KIRKLEES METROPOLITAN COUNCIL INVESTMENT & REGENERATION SERVICE

DELEGATED DECISION TO DETERMINE PLANNING APPLICATIONS

Reference No:	2025/62/91943/W
Site Address:	Mellbreak, 161, Causeway Side, Linthwaite, Huddersfield, HD7 5SJ
Description:	Erection of rear extension and rear dormers and alterations to roof (within a Conservation Area)
Recommending Officer:	Joshua Merriman

Officer Report – 2025/91943

Description  
PROPOSED SITE PLAN

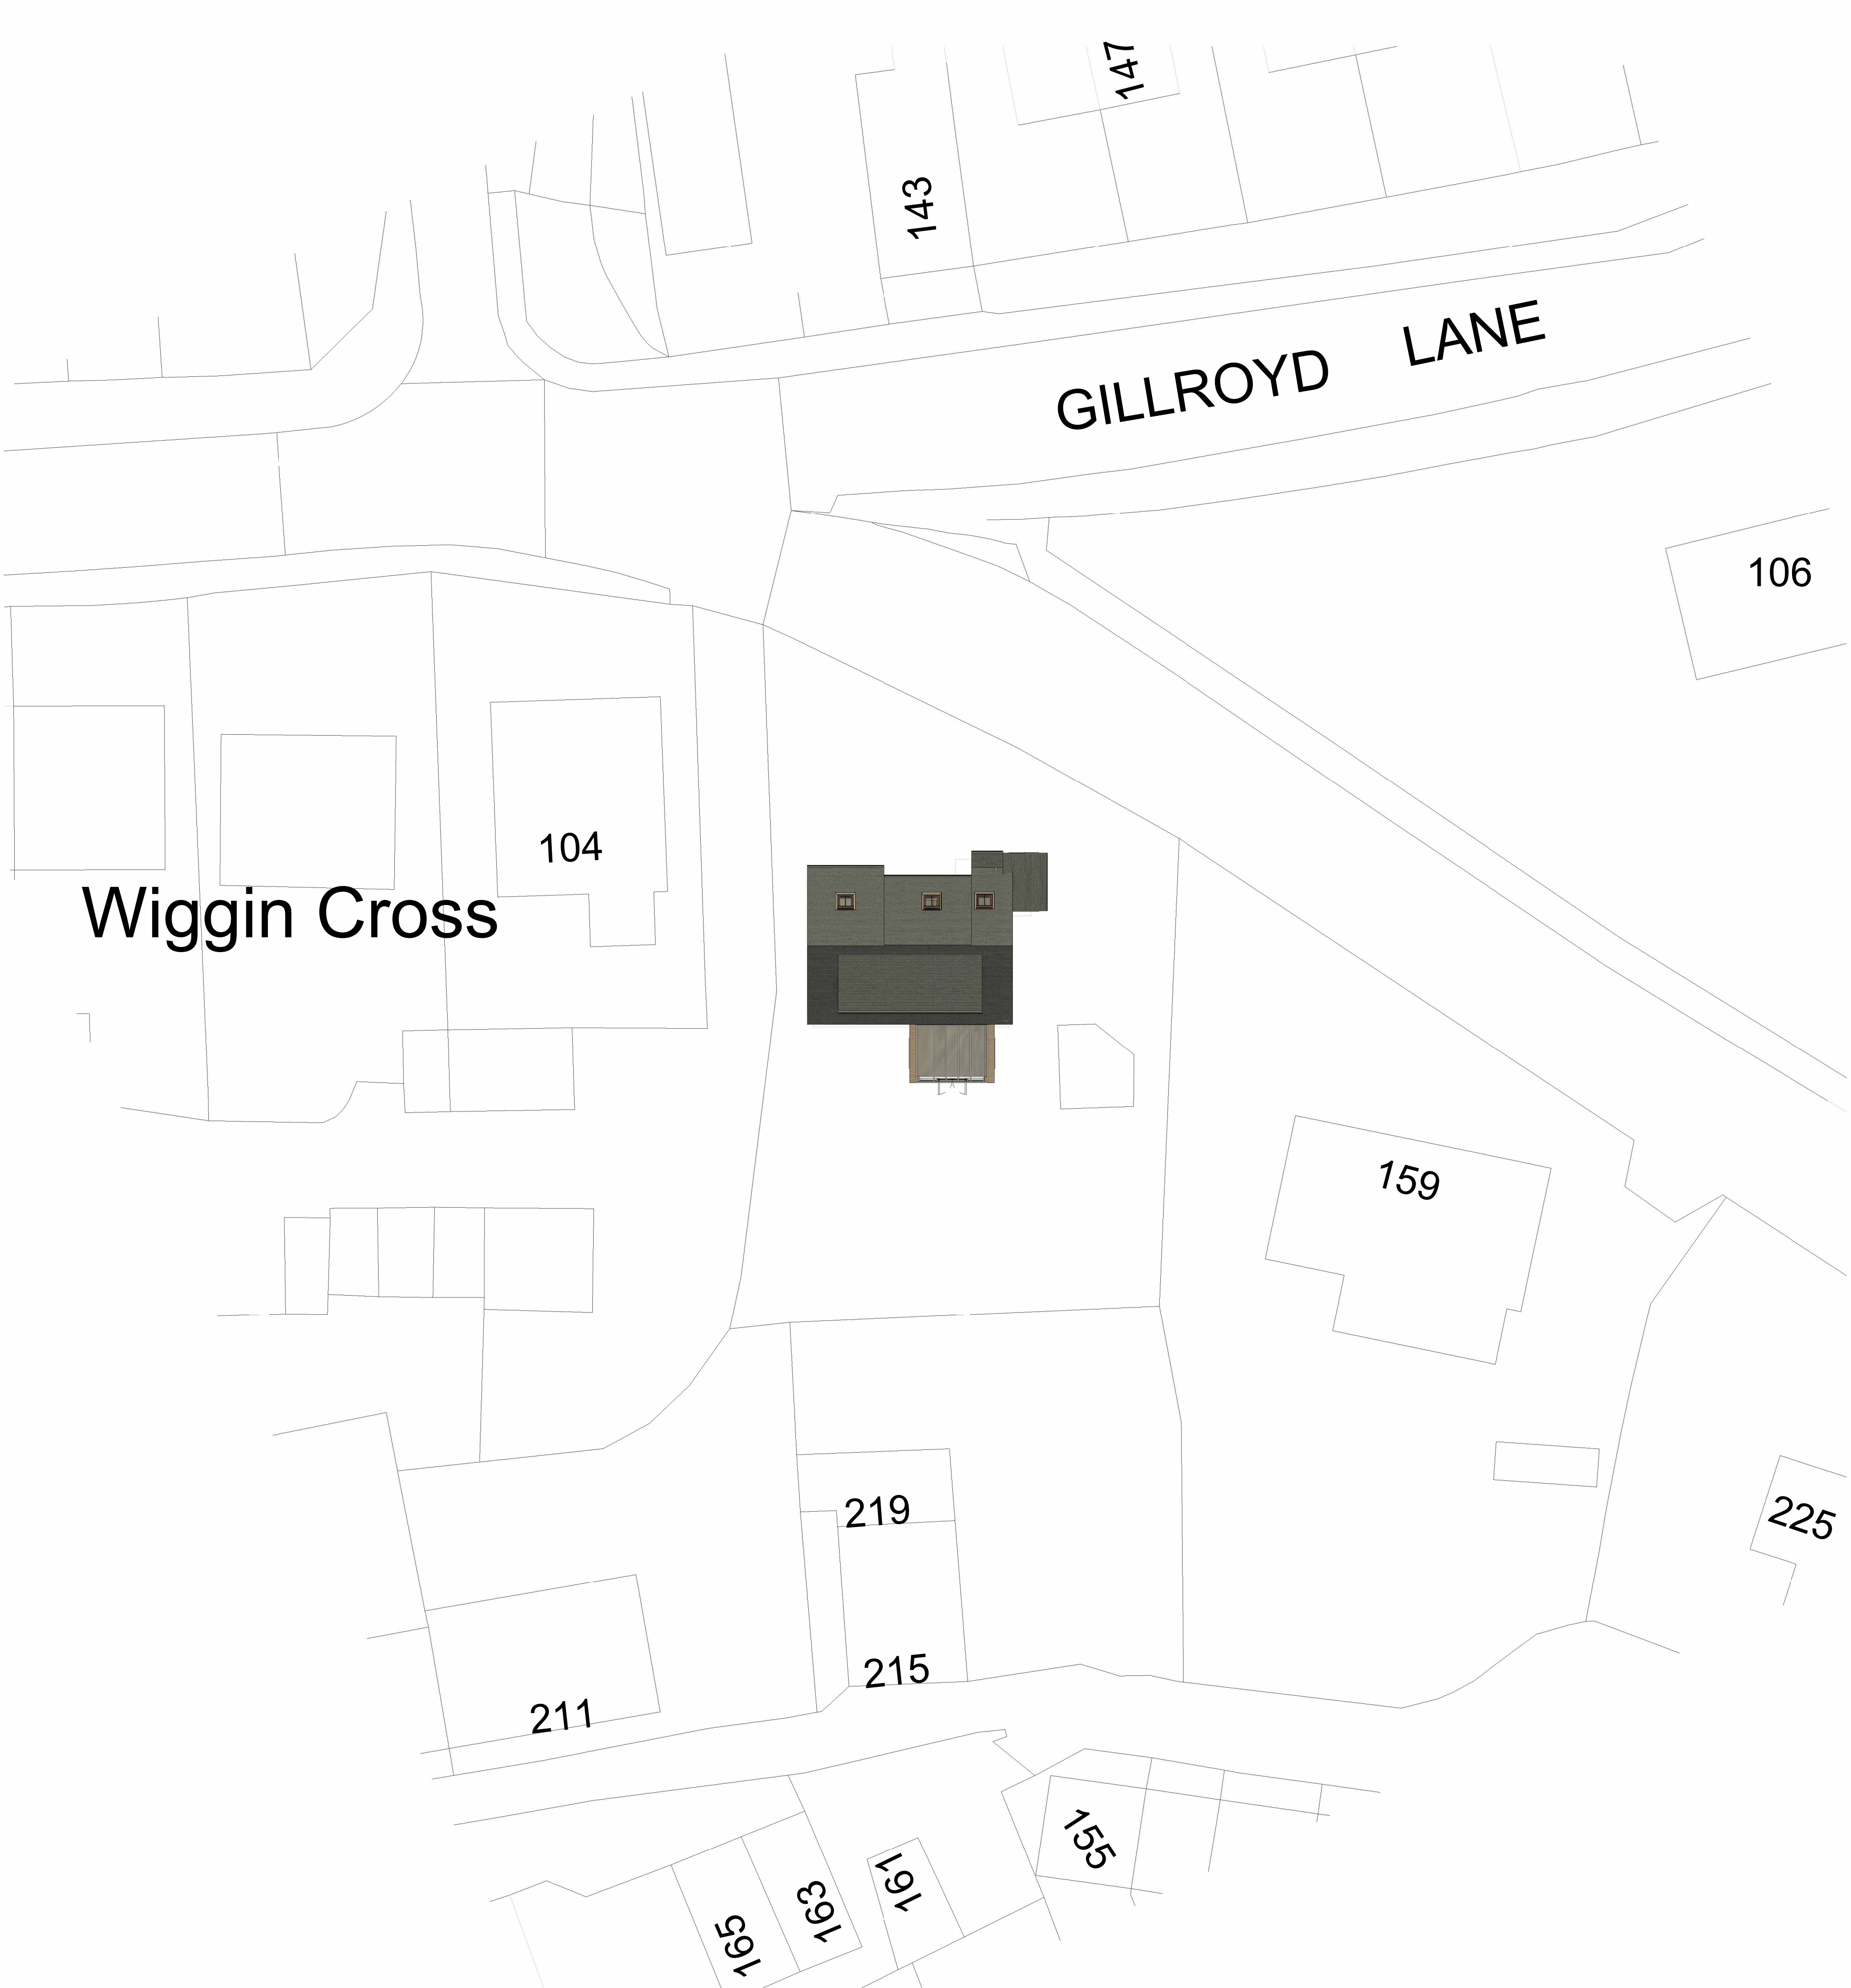
There is a driveway and parking area to the side of the property which can accommodate 3 no. vehicles and therefore, it is considered that the parking available for the property is adequate.

Client MR K RAD		
Project 161 CAUSEWAYSIDE, LINTHWAITE, HUDDERSFIELD, HD7 5SJ		
Project No 2951	Drawing No (100)03	Rev C
Description PROPOSED PLANS AND ELEVATIONS

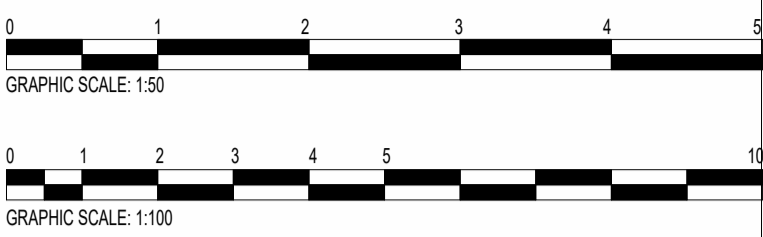
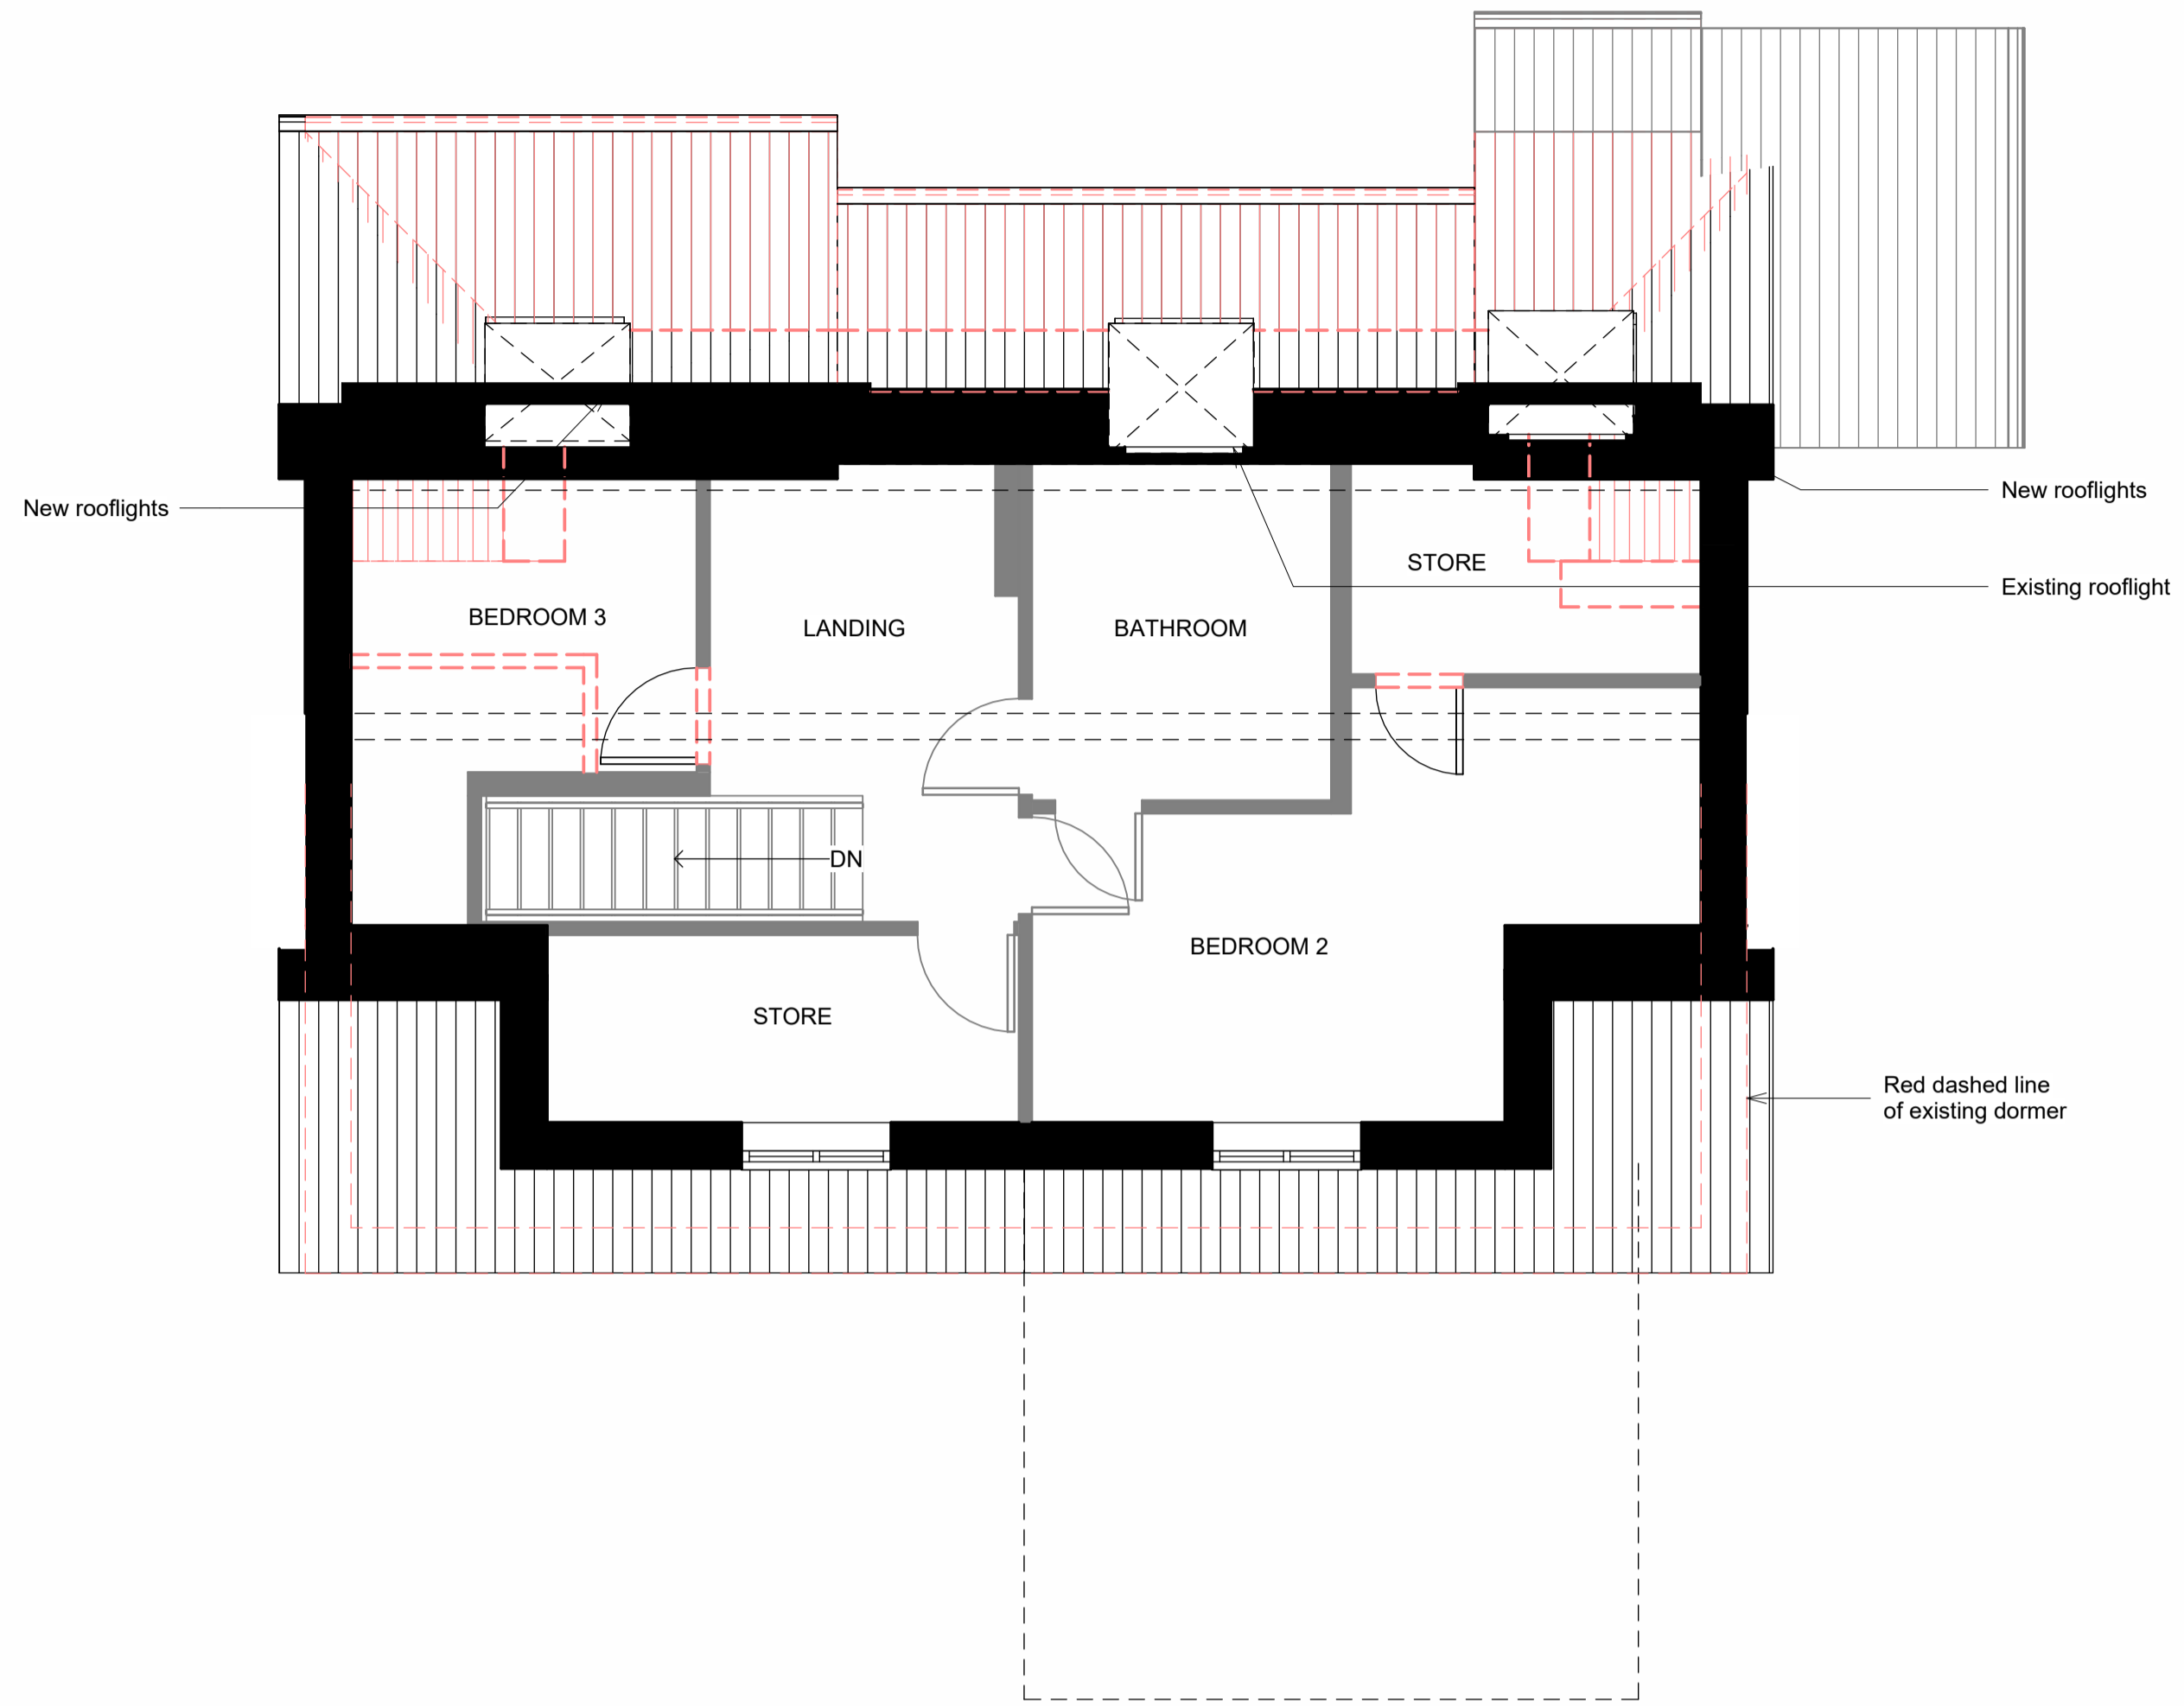
The design of the proposed dormer has been amended to a small subservient structure which is sympathetic to the existing roof plane and property. The amended plans show alterations to the roof that prevent the rear dormer from projecting beyond the roofline as shown in the original plans, as well as hiding the rear extensions somewhat from the front elevation. The rear dormer has also been detailed to be faced in matching roof tiles.

Although the proposed gable roof was additionally considered to add to concerns of bulk and massing on the site, the amended plans showing a reduced scale dormer show the gable roof to appear more acceptable within

With regard to the proposed single storey rear extension, this structure broadly aligns with the SPD. The extension is single storey in height, does not cover more than 50% of the land around the property and is set in from shared boundaries by more than 1 metre. Whilst the construction materials do not match the host dwelling, the contrasting materials ensure that the extension is an addition to the property and not part of the original build. Due to its location and limited size, it is not considered that this element of the proposal would have undue harm to visual amenity.

However, due to floor levels, the extension is set up significantly above the ground level and upon a terraced area. As outlined in the earlier officer note, these developments on site are now legal by virtue of the time they have been erected, therefore, the supporting structures in relation to the rear extension, although unsympathetic and not preferred, cannot be acted against in this case as they are now lawful.

In terms of residential amenity, openings are within the rear elevation of the dormer extension and within the sides and rear of the orangery extension. Whilst the dormer creates openings within the rear elevation of the property, the established separation distances between the site and neighbouring

In terms of overbearing and overshadowing, the rear dormer and additions to the roof are considered to be overbearing but not to such a degree that the structure would be oppressive to neighbouring dwellings. Moreover, there are minimal concerns regarding the single storey rear extension due to its limited scale and size.

3. The face and cheeks of the dormer hereby approved shall be faced in vertically hung tiles which shall in all respects match those used in the construction of the existing building. The dormer shall thereafter be retained with this finish.
